APPLICATION FOR: 17611/APP/2022/993

42 FIELD HEATH ROAD HILLINGDON

Item No. Report of the Interim Director of Planning, Regeneration & Public Realm**Address** 42 PIELD HEATH ROAD HILLINGDON**Development:** Demolition of a two-storey bed and breakfast, and the erection of a three-storey residential development comprising of seven flats, alterations to existing drop kerb, all associated external works and landscaping.**LBH Ref Nos:** 17611/APP/2022/993**Drawing Nos:** 555/B/09
555/B/01
555/B/02
555/B/03
555/B/04
555/B/05
555/B/06
555/B/07
555/B/07
555/B/08
555/B/08**Date Plans Recieved:** 23/03/2022**Date(s) of Amendment(s):****Date Application Valid:** 23/03/2022**1. SUMMARY**

| .            | 555/B/03                                 | .         |          |

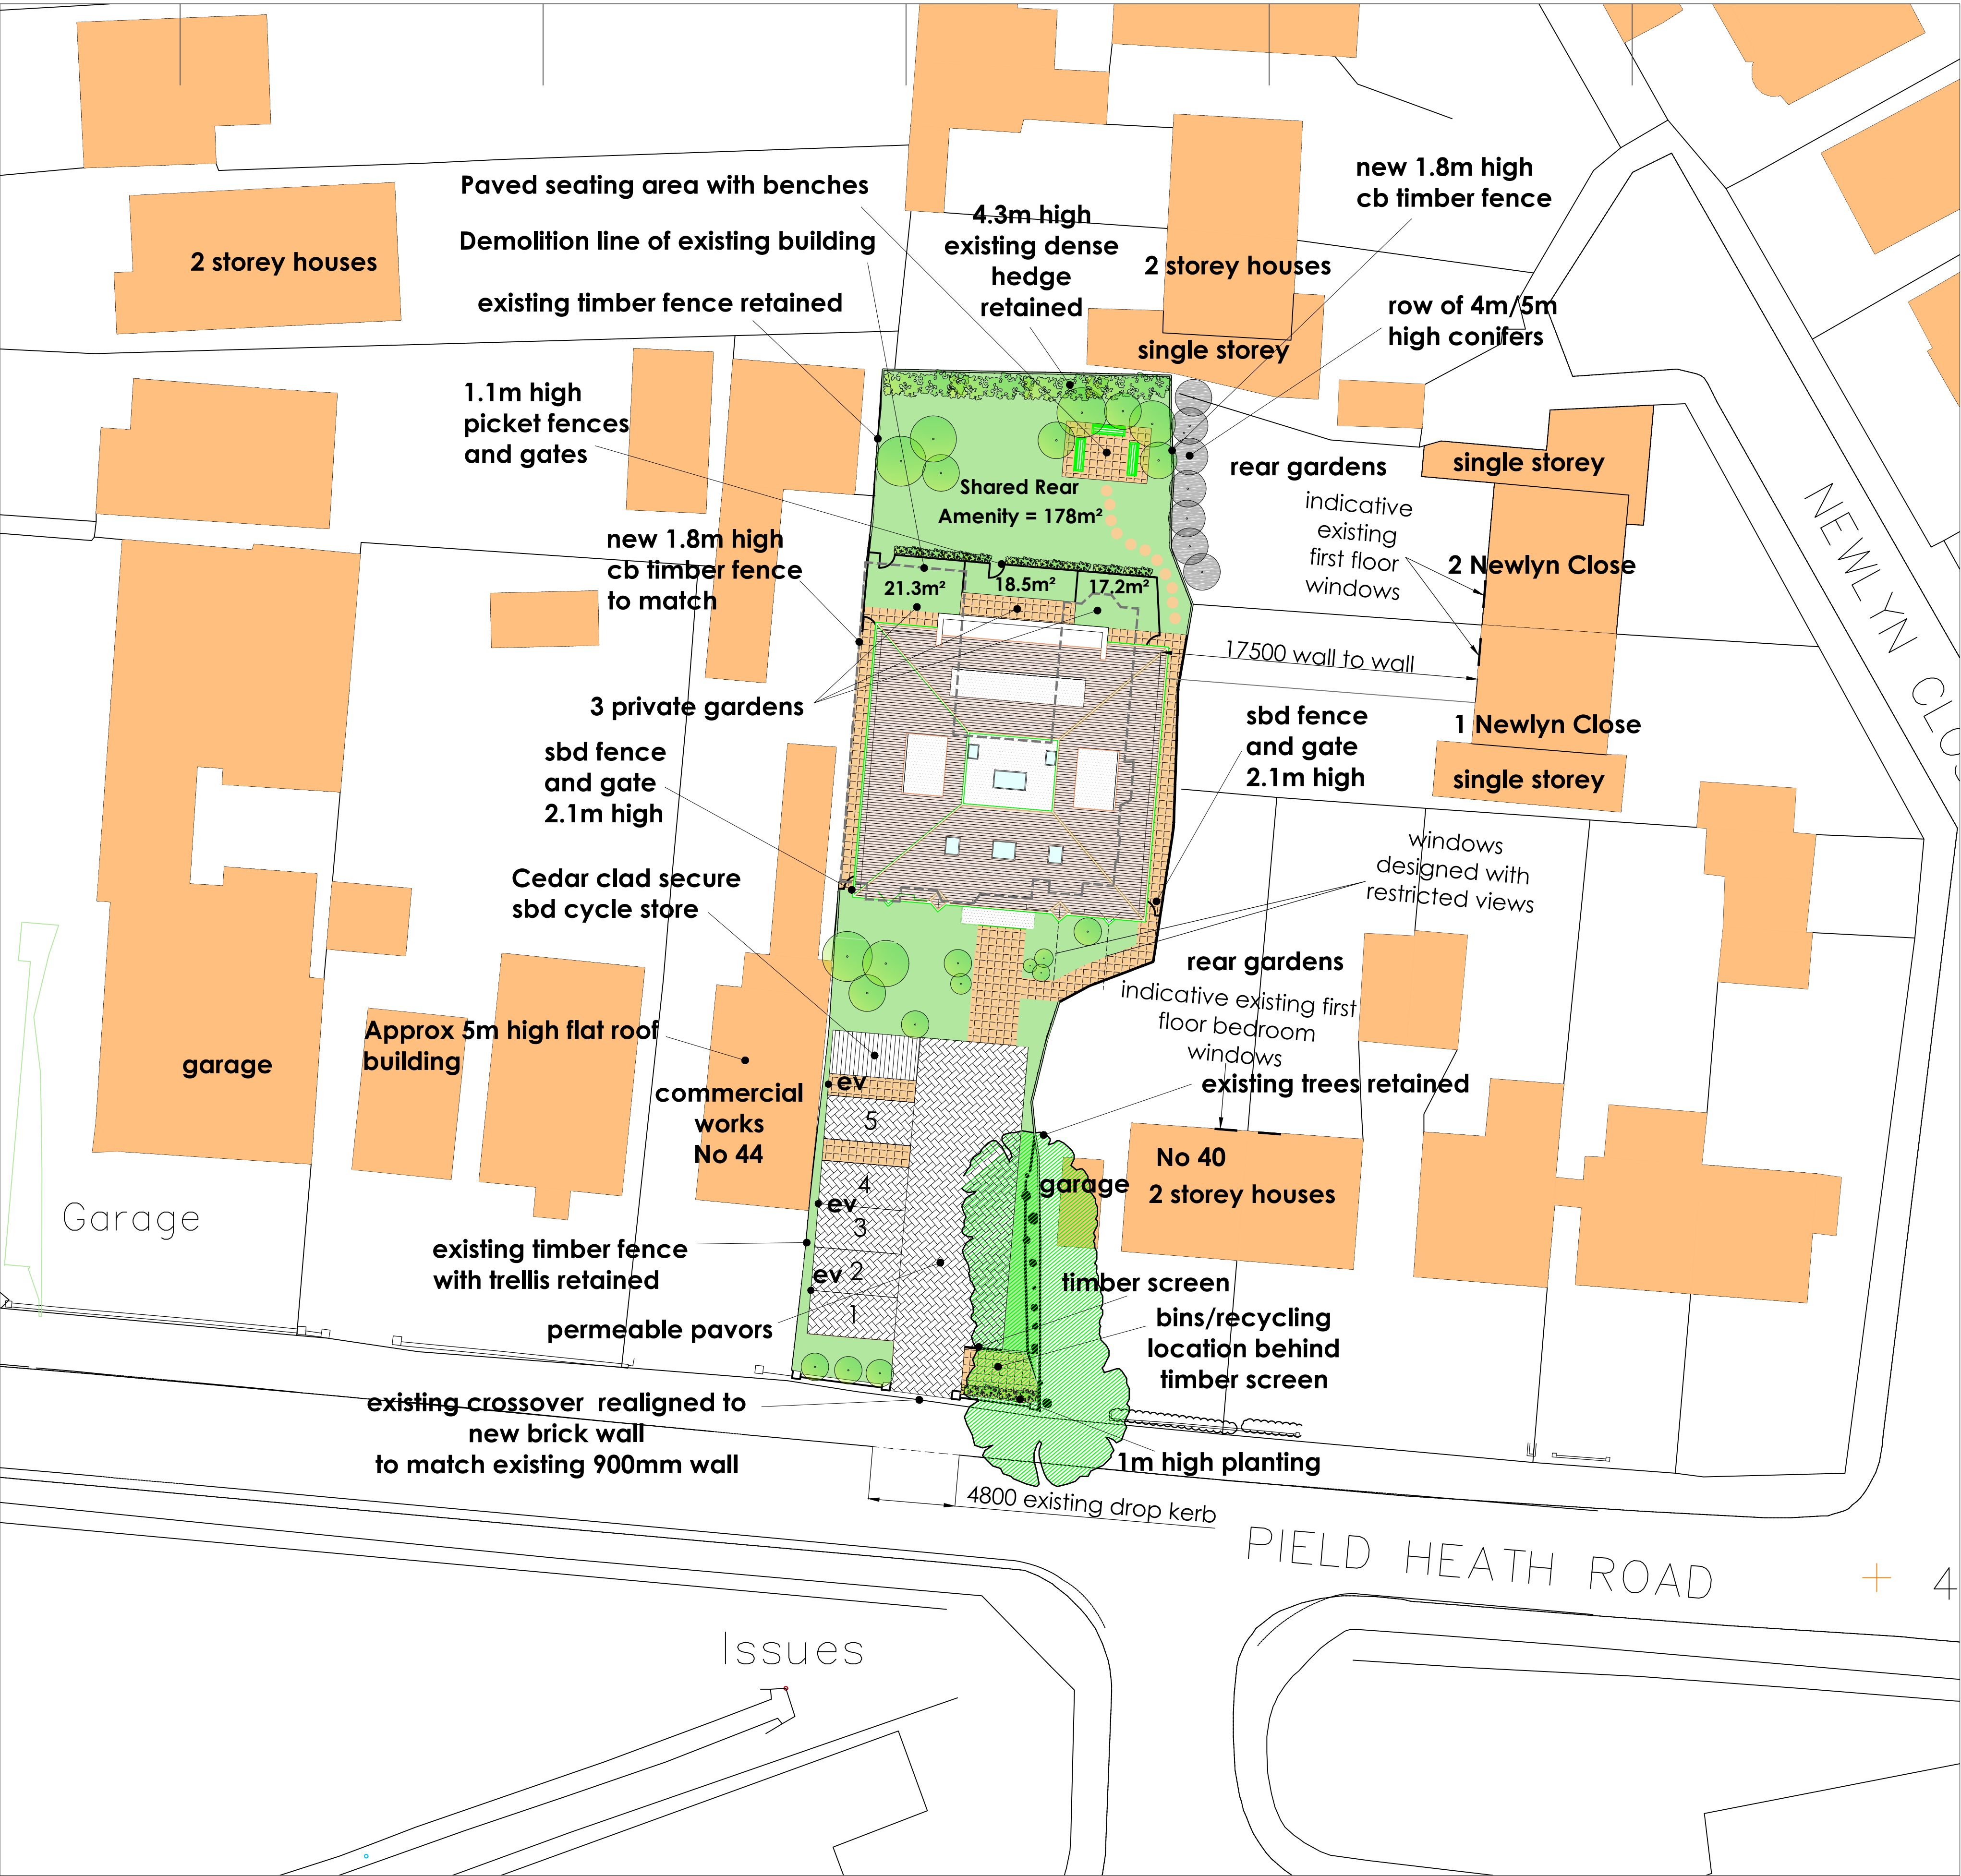
42 Pield Heath Road will utilise the existing vehicle crossover, with some changes being made to it. However, the development wishes to introduce a 1-metre-high planting to the east and realign the wall to a new 900mm wall.

This would be too high and would block line of sight for vehicles exiting the site, which presents safety concerns for pedestrians from exiting vehicles. This is in breach of the published London Borough of Hillingdon's Domestic Vehicle Footway Crossover policy June 2022 which states that 'fences, walls and shrubs should be kept to a maximum height of 0.6m' and the published London Plan Policy T4 Assessing and mitigating transport impacts which states that 'development proposals should not increase road danger'.

As mentioned above the development will be on-site cycle storage parking for the residents. However, the submitted site plan dated 10/09/2022 makes no mention of the quantity that will be provided, which makes an accurate assessment difficult to do. For a development of this type to be within policy at least 12no. would need to be provided. Therefore, this proposal contradicts the London Plan 2021 Policy T5 Cycle which requires to developments 'provide the provision of appropriate levels of cycle parking which should be fit for purpose, secure and well-located and be in accordance with the minimum standards'.

SITE:	42 FIELD HEATH ROAD UXBRIDGE MIDDLESEX UB8 3NP	
SCALE BAR:	 0 1 2 4 6 8 10m	
DESCRIPTION:	PROPOSED FLOOR PLANS & ROOF PLAN	
SCALE:	1:200 @ A3	DATE: SEPT 2022
DRAWING NO.:	555/B/06	REV

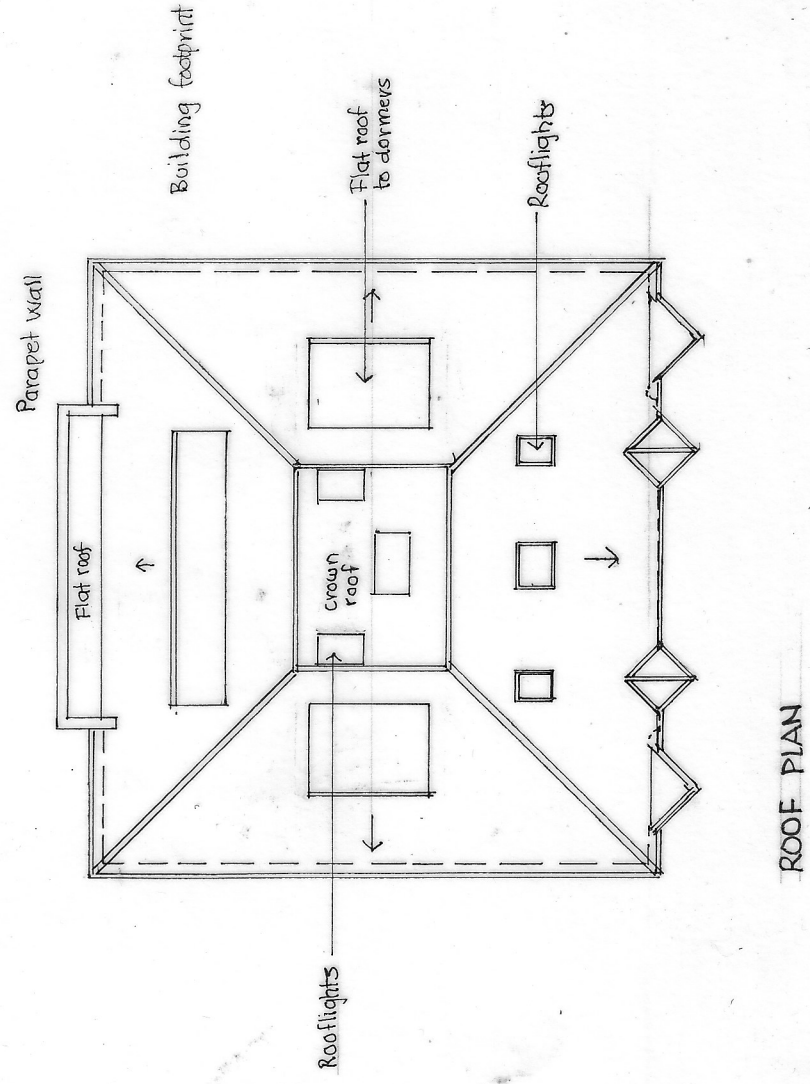
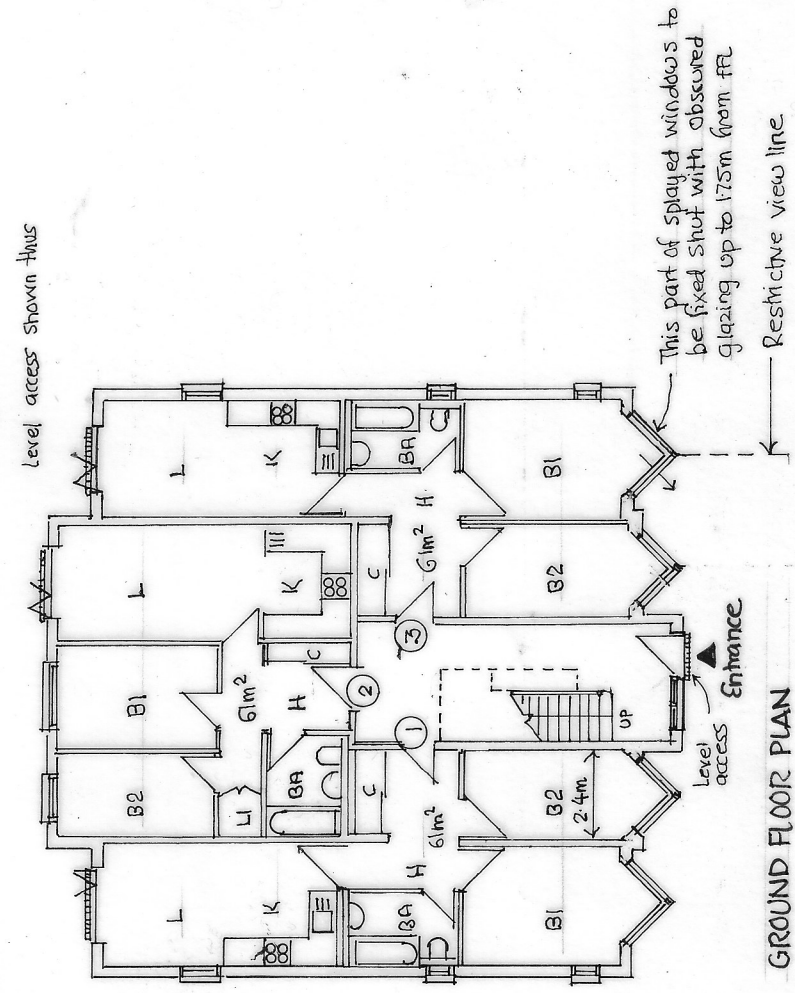
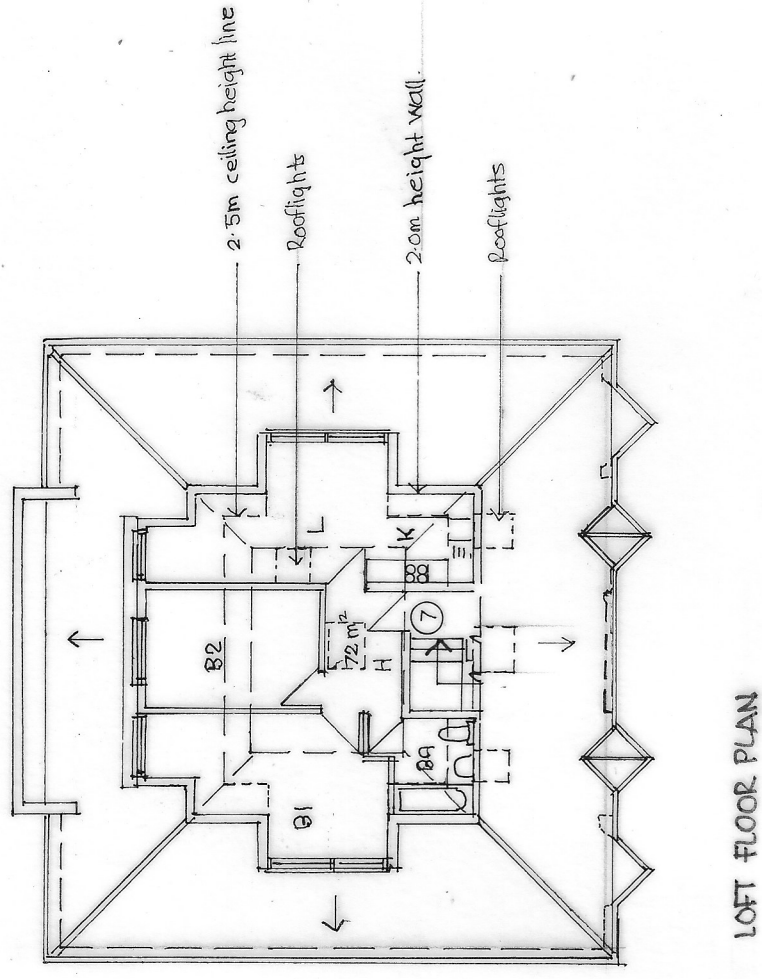
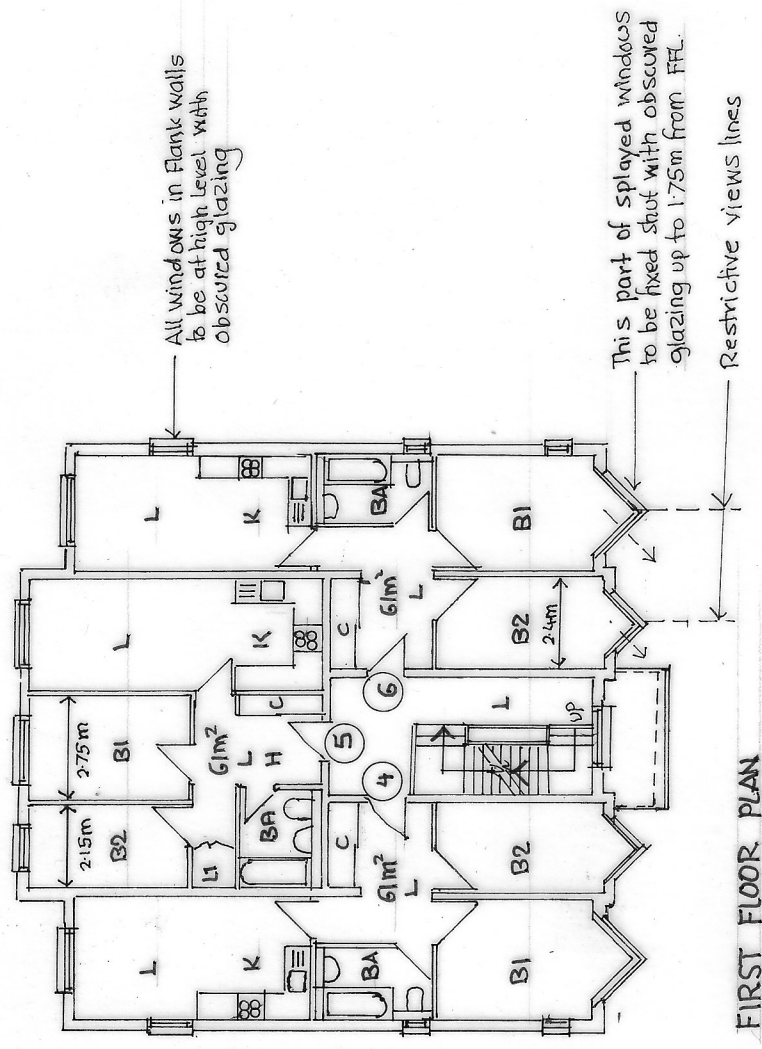
In response to point 14, the proposed floor plans show a green roof and solar panels. However the floor plans do not match the proposed roof plan. Had the application been recommended for approval the discrepancy would have been addressed by requesting amended plans. Additionally had the application been recommended for approval, a condition would have been recommended requiring full details of the green roof and solar panels.

SITE:		42 PIELD HEATH ROAD UXBRIDGE MIDDLESEX UB8 3NG	
SCALE BAR		0 1 2 4 6 8 10m	
DESCRIPTION:		PROPOSED EAST & SOUTH ELEVATIONS	
SCALE:		1:200 @ A3	
DRAWING No:		555 / A / 07	
		SEPT 2022	
		DES

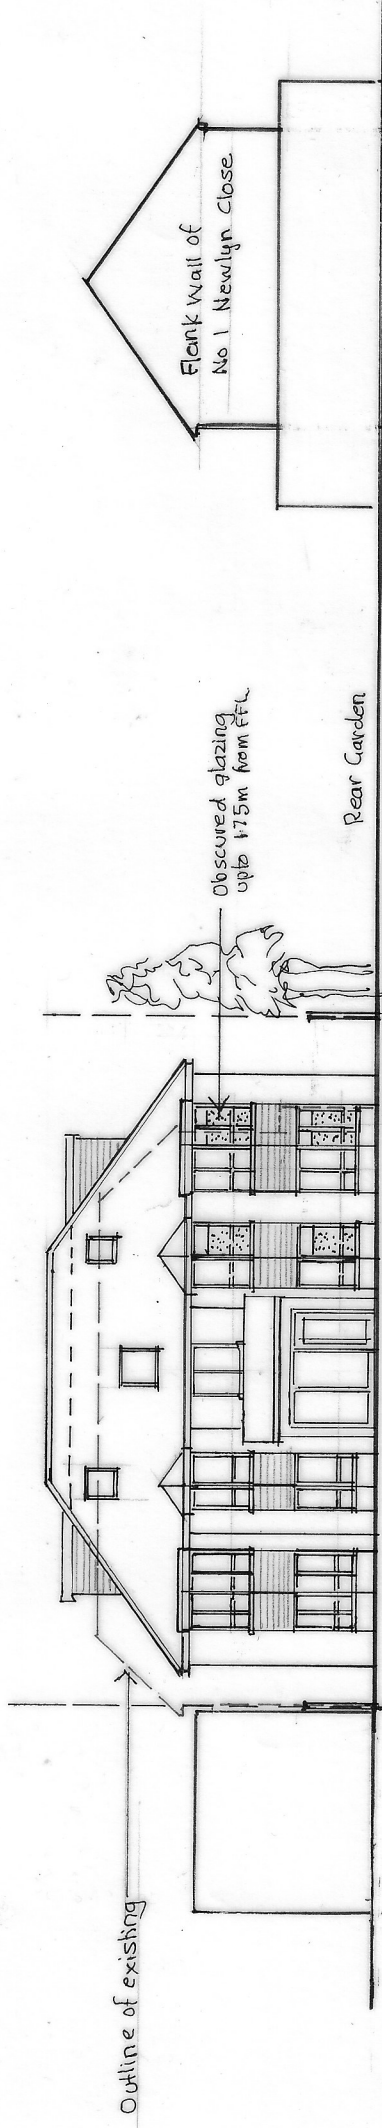
The new building would be approximately 8.8m high, 15.5m wide and 16.8m deep. It would be finished in bricks, clay tiles and upvc window and would have a stepped frontage with triangular windows, rear and side dormers and a very large crown roof. It is also worth noting that a green roof with solar panels is proposed on the submitted second floor plan, however that plan does not match the roof plan. Were the application recommended for approval, this would have been resolved or conditioned, but does not change the outcome of the assessment as a whole.

The roofscape of the area is characterised by pitched roofs and this is evident in all views on and around the site. The proposed crown roof would therefore be out of character with the established roofscape of the area, adding to the bulk, massing and design concerns.

Together, the bulky crown roof, partially obscure glazed triangular bay windows, squat dormers, stepped and blocky rear elevation are considered to result in a contrived, poorly designed building, which has no similarity to other buildings in the area, making it an uncharacteristic and unsympathetic addition to the area in terms of its design.
